Our Case Number: ABP-318540-23

Re: 10 year planning permission for the proposed Open Cycle Gas Turbine (OCGT) power plant fuelled by Hydrotreated Vegetable Oil (HVO) and associated site works at Tarbert Island, Tarbert, Co. Kerry. (www.ssetarbertnextgen.com)

Date: 1st February, 2024

Re: Strategic Infrastructure Development - ABP- 316229 – Proposed 350MW Low Carbon Open Cycle Gas Turbine (OCGT) fuelled by hydrotreated vegetable oil, administration building and workshop, and ancillary plant and infrastructure in Tarbert Power Station, Tarbert, Co. Kerry

Water Tanks & Fire Water Module
 Plans & Elevations
 Sheet 1 of 2

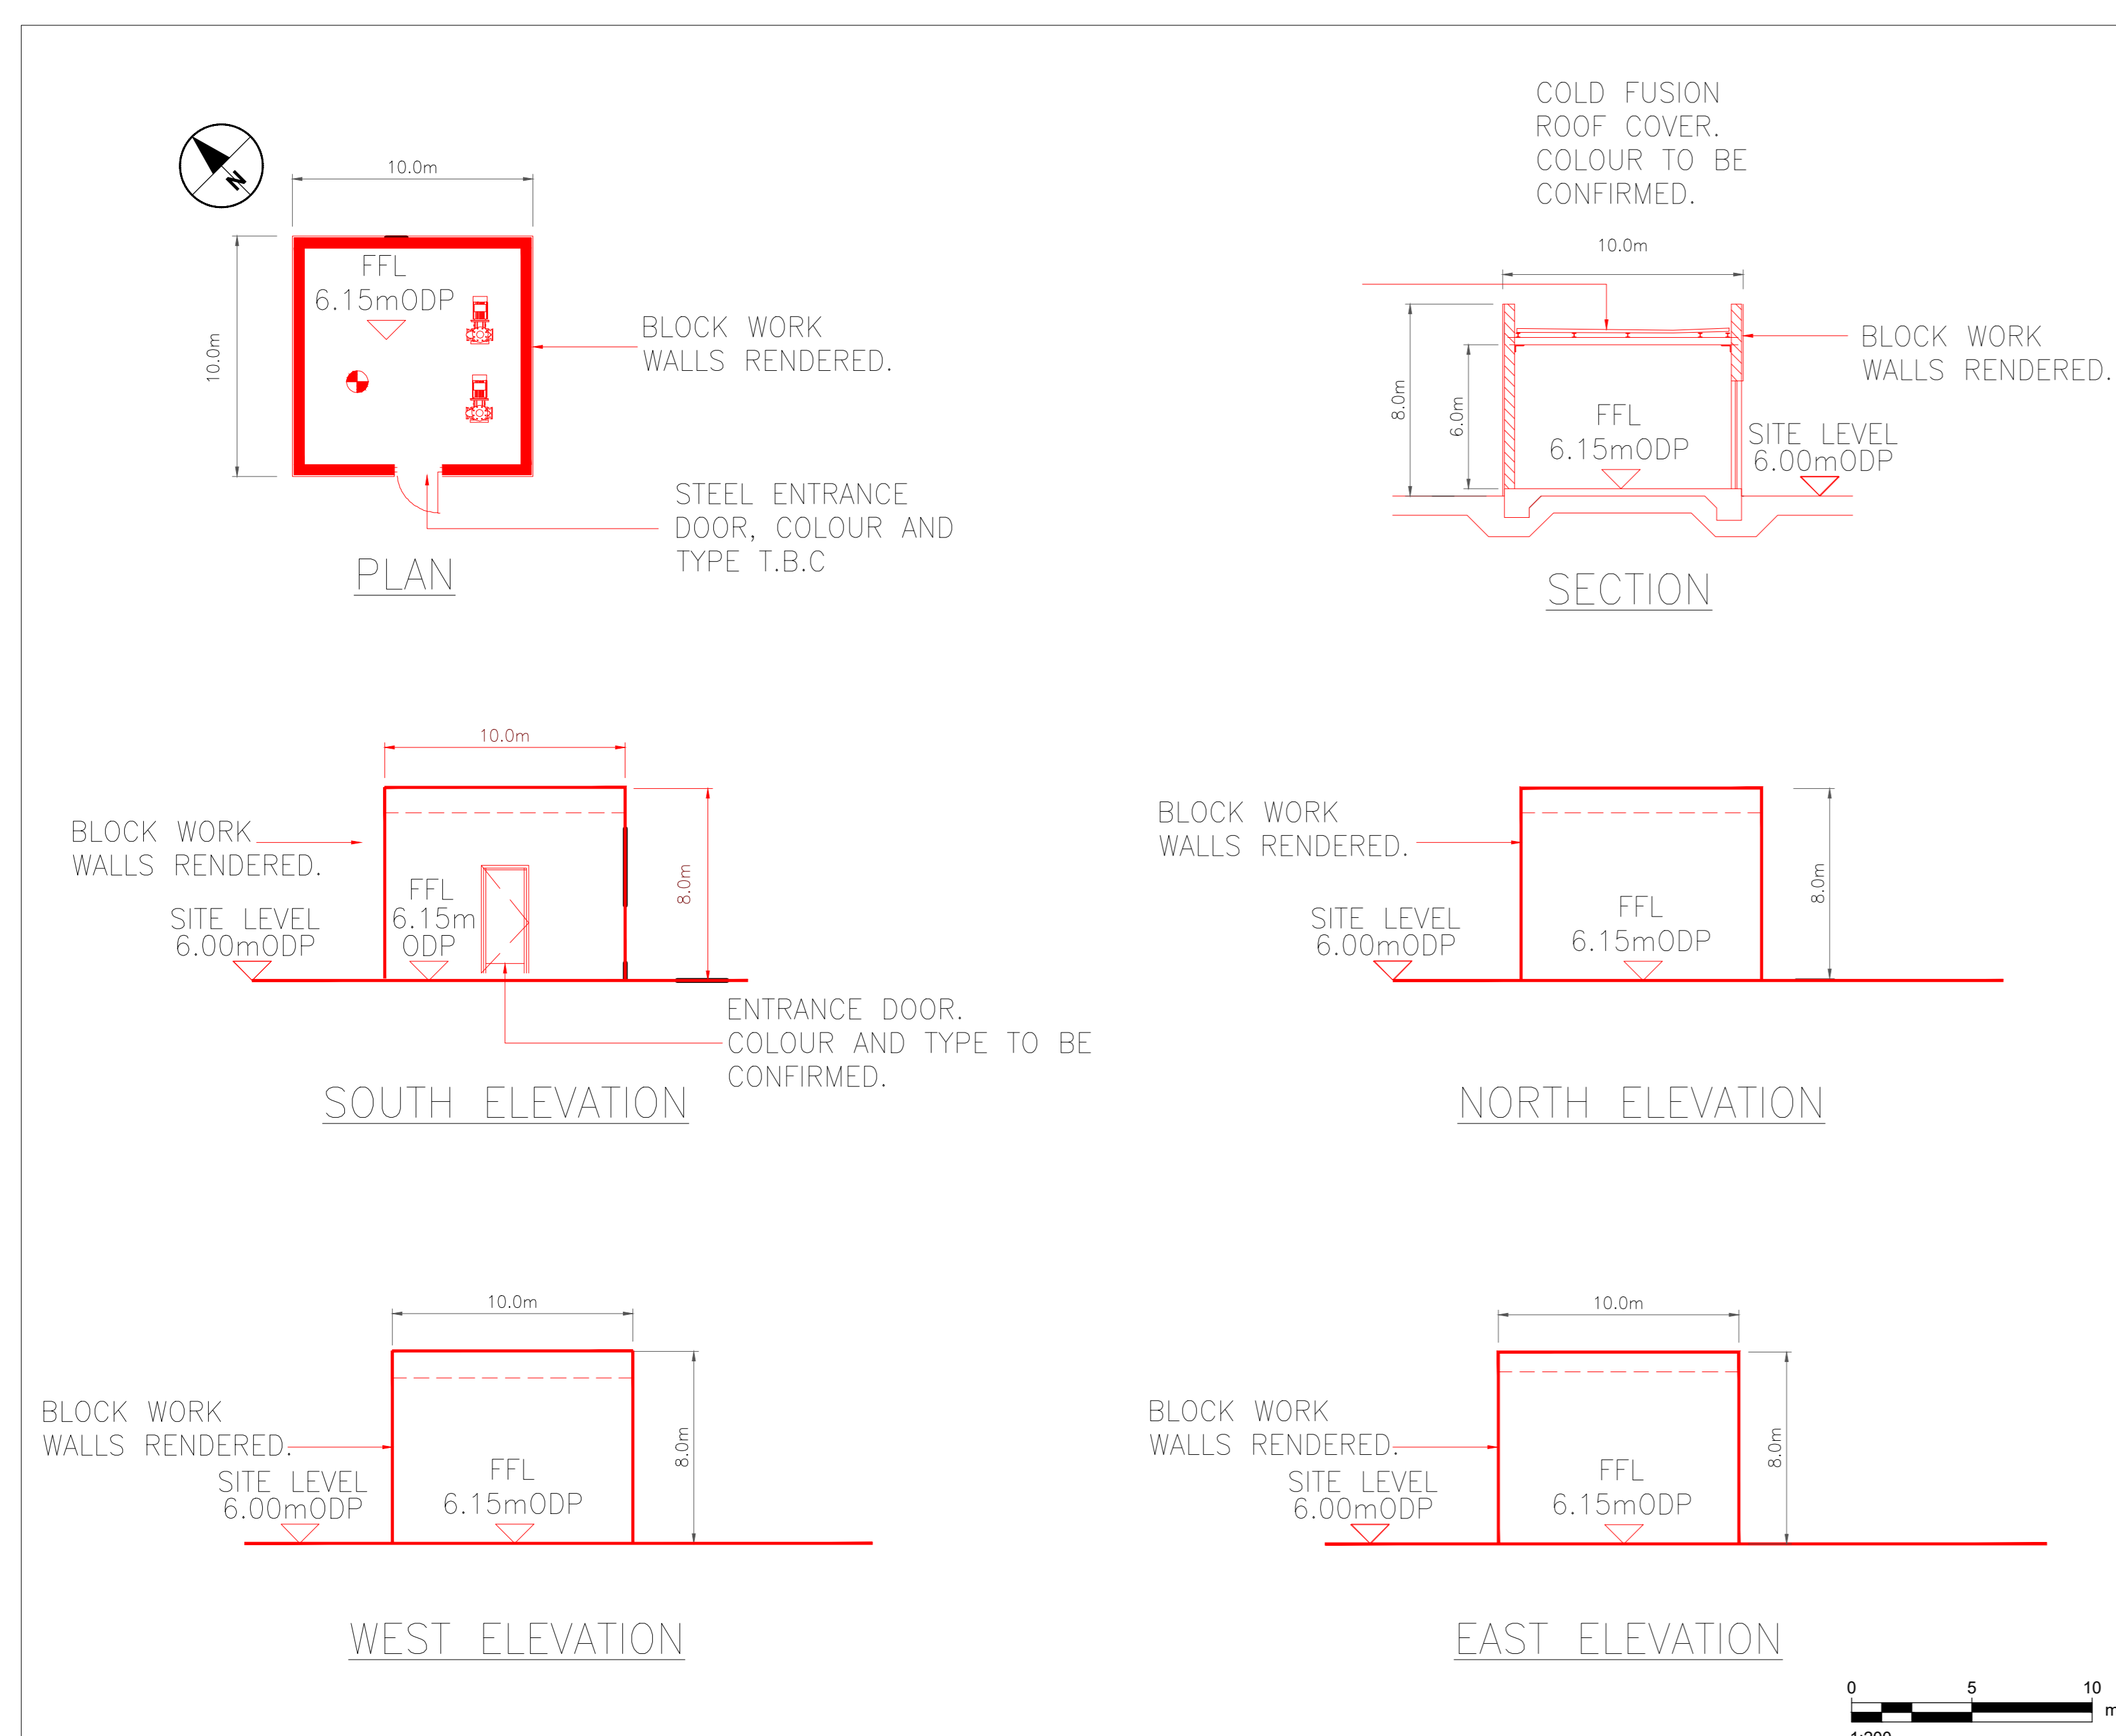
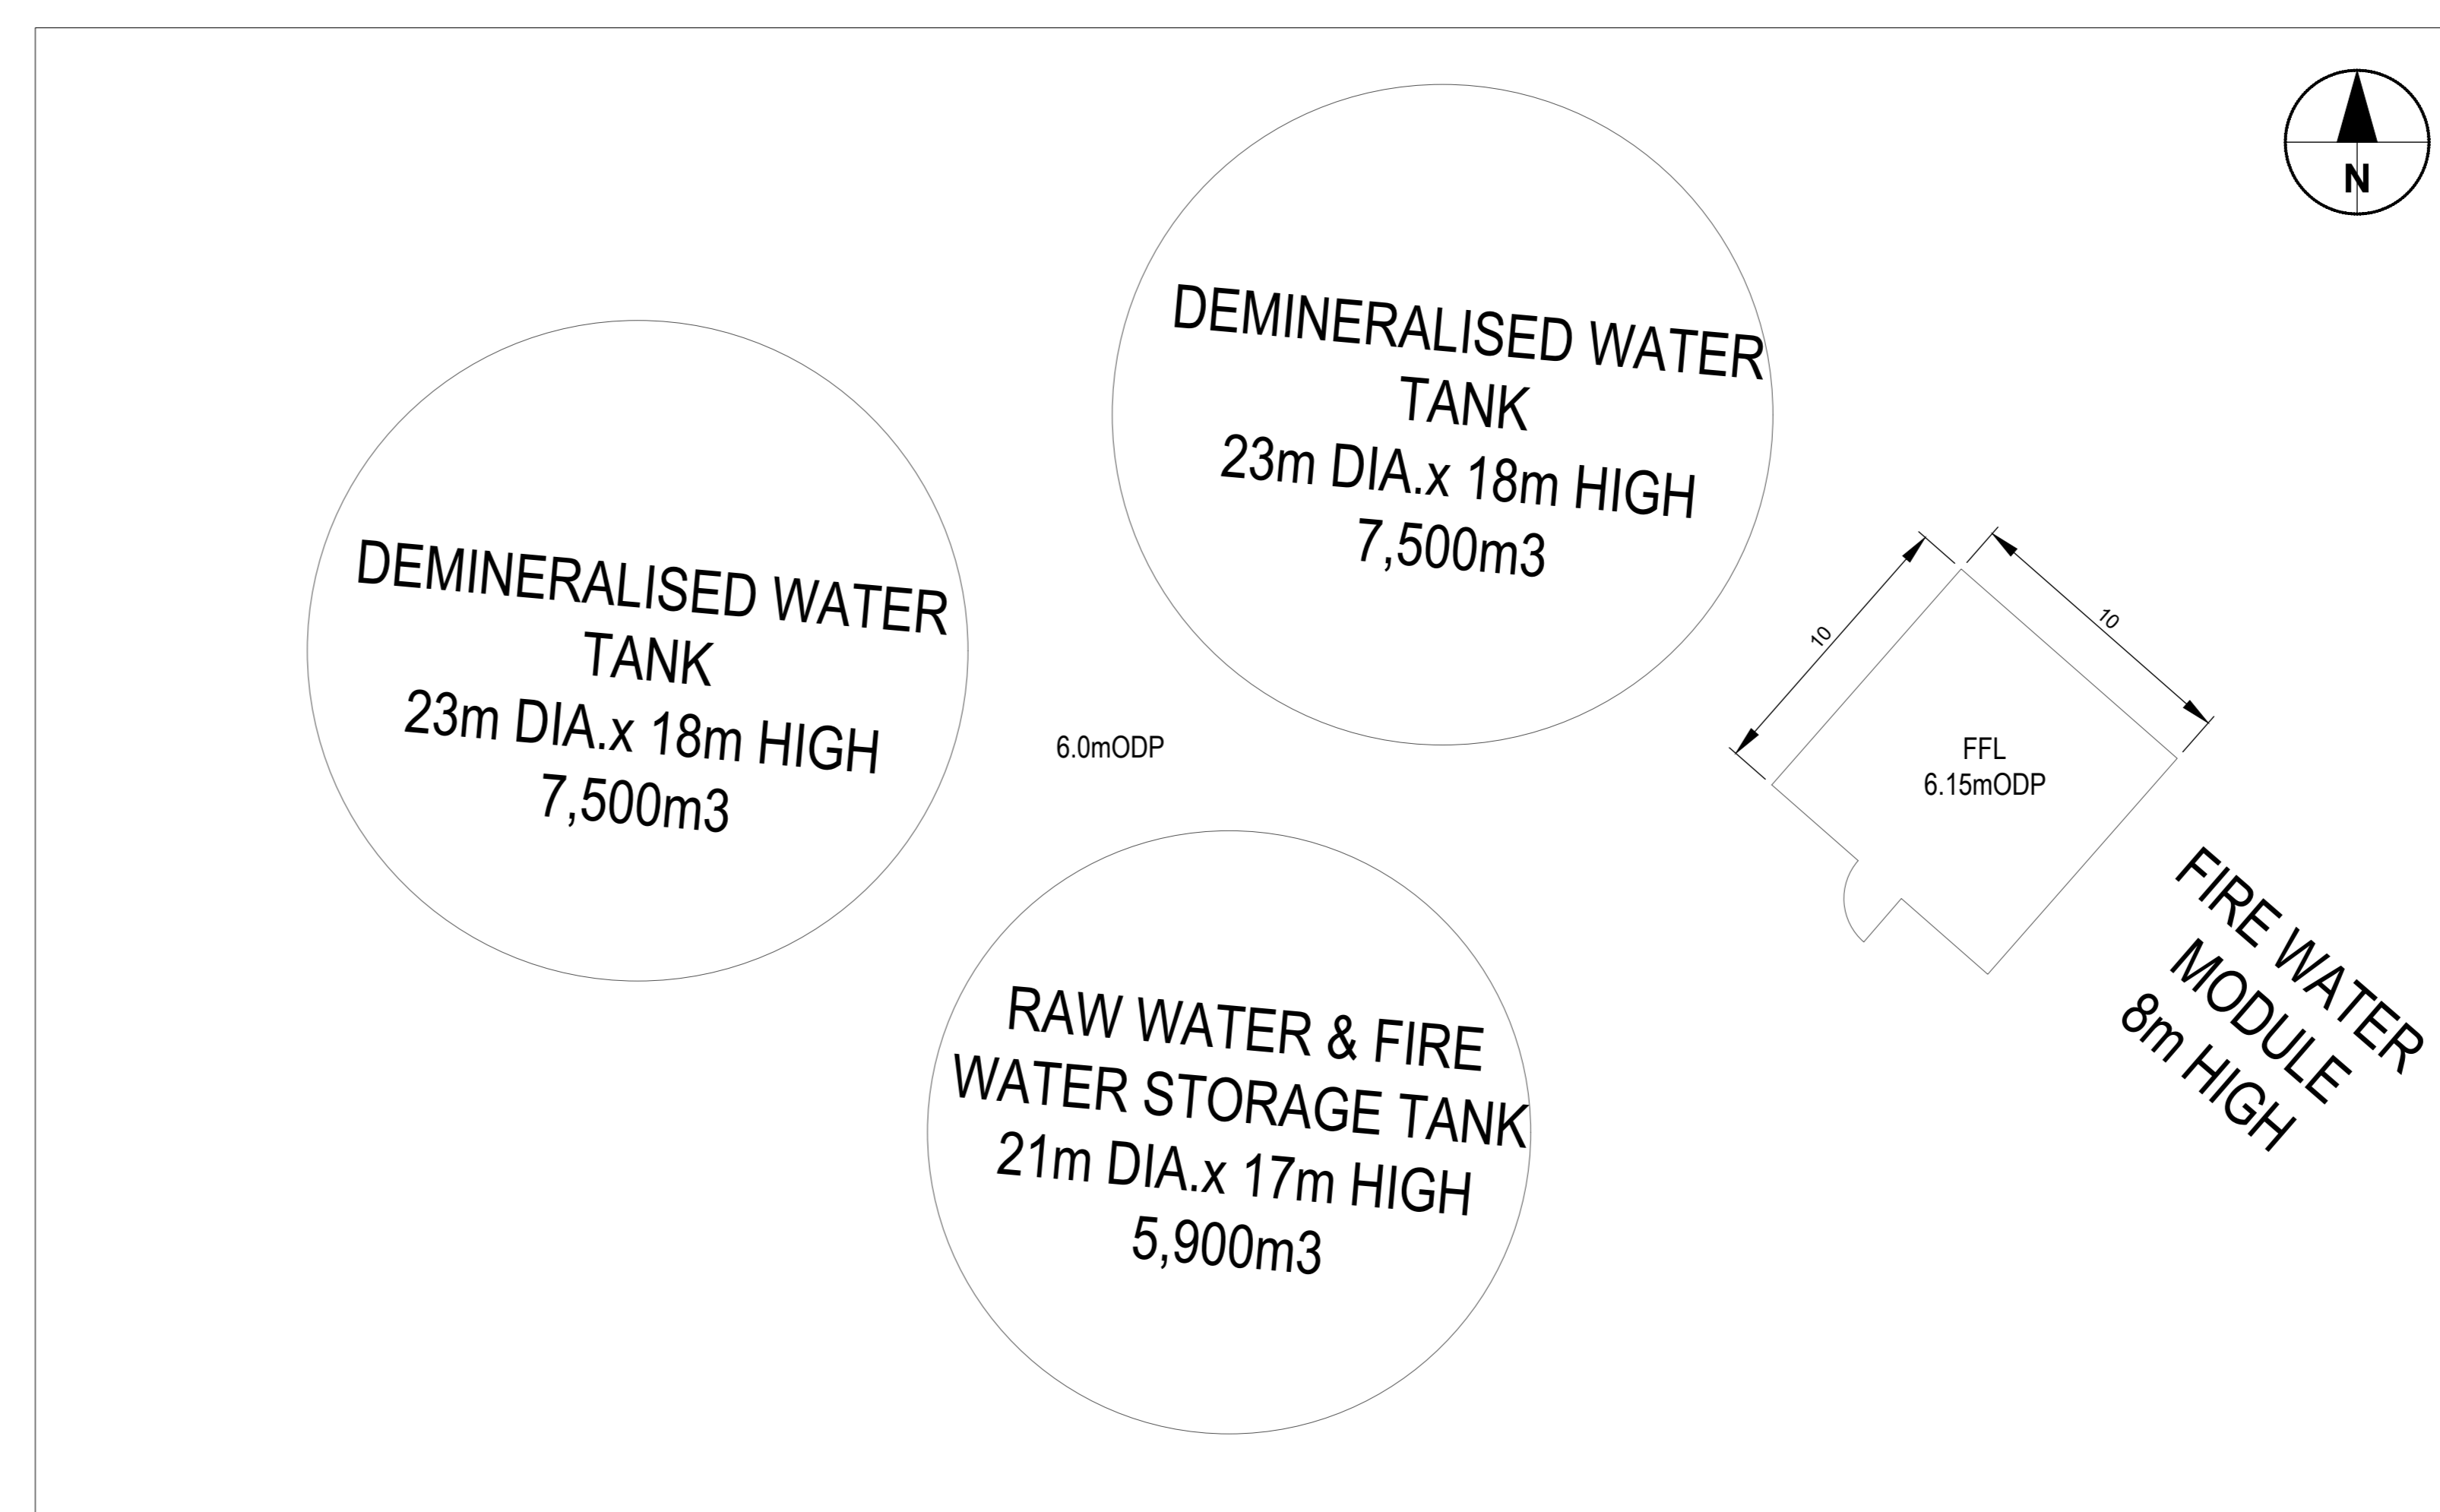
It is noted in Section 5.2.5 'Water Supply' in the Environmental Appraisal Report that it is expected when in operation, the proposed development will require up to c.150m³ per hour of demineralised water. Whilst UÉ notes the overall proposed reduction in water usages, the supply remains significant and volumes of this nature, in addition to the proposed firewater/water storage tank of approximately 5,900m³ will need to be considered as part of UÉ's feasibility assessment.

UÉ have subsequently been in contact with the Applicant's agent and have been provided with some further detail/ figures in terms of the proposed volumes of water usage. UÉ have some concerns with the figures being proposed, particularly what the peak flows might be and the potential impacts on the reservoir storage as well as the impacts on existing watermains and networks.

- Calculations including peak and seasonal water demand profiles
- To include:
 - Details for the proposed 2 no. Demineralised water storage tanks
 - Details for raw water and fire water storage tank
- Detailed and current demand profiles to inform supply and hydraulic modelling

- The applicant shall engage with Uisce Éireann by submitting a pre-Connection Enquiry (PCE) to assess feasibility of connection to the public water / wastewater infrastructure.
- The outcome of the PCE is to be submitted as a response to Further Information Request.
